Rezoning Transportation Analysis

Petition Number: Insert Zoning Petition #2022-006

Date	Description
06-23-22	First Review (PDM)
07-20-22	Second Review (PDM)

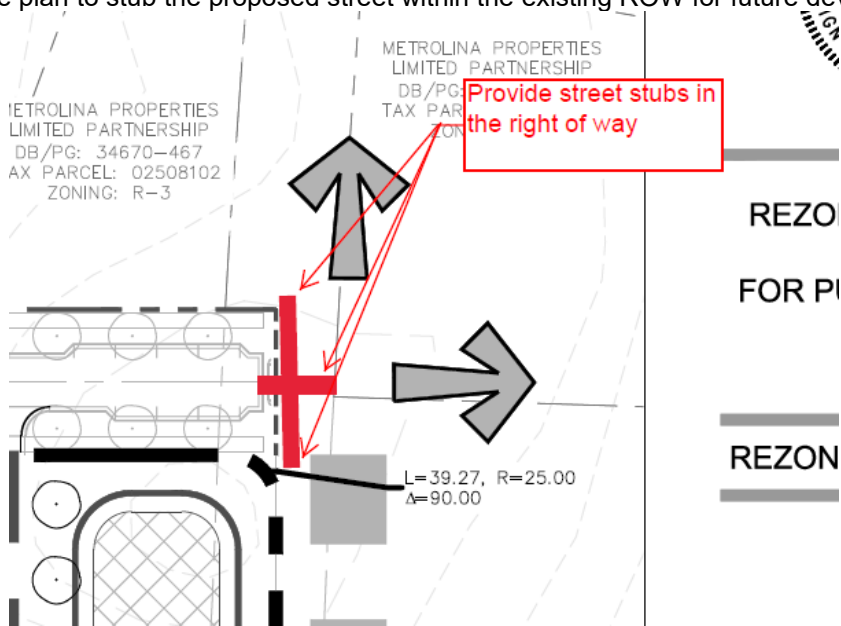
- Outstanding Comment from 06-23-22:** Revise site plan and conditional note(s) to commit to installing both public streets that are identified as "public street by others" on the site plan. A new access location on Northlake Centre Parkway will be required by CDOT for this petition. Coordinate roadway responsibilities with RZP 2022-010 as necessary.

Clarifying Comment (07-20-22): Remove "By Others" from the proposed public roadways and adjust callout for street installation commitments to include both public roads.

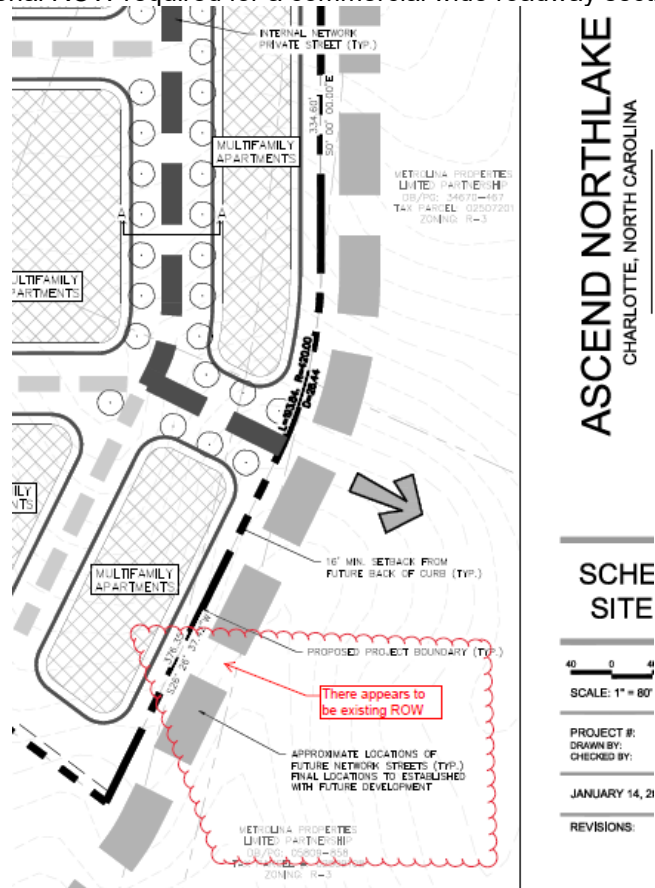
4. **Outstanding Comment from 06-23-22:** Revise site plan and conditional note(s) to commit to dedicate 38.5 right-of-way from the road centerline of each public street. The site plan shall label and dimension the right-of-way from the road centerline.
5. **Outstanding Comment from 06-23-22:** Revise site plan to stub the proposed street within the existing ROW for future development.

- Outstanding Comment from 06-23-22:** Revise site plan and conditional notes to reconcile the existing versus proposed ROW along the east side of the property. The future street alignment should fall within existing ROW. Verify ROW width and provide any additional ROW required for a commercial wide roadway section per CLDSM U-05A.
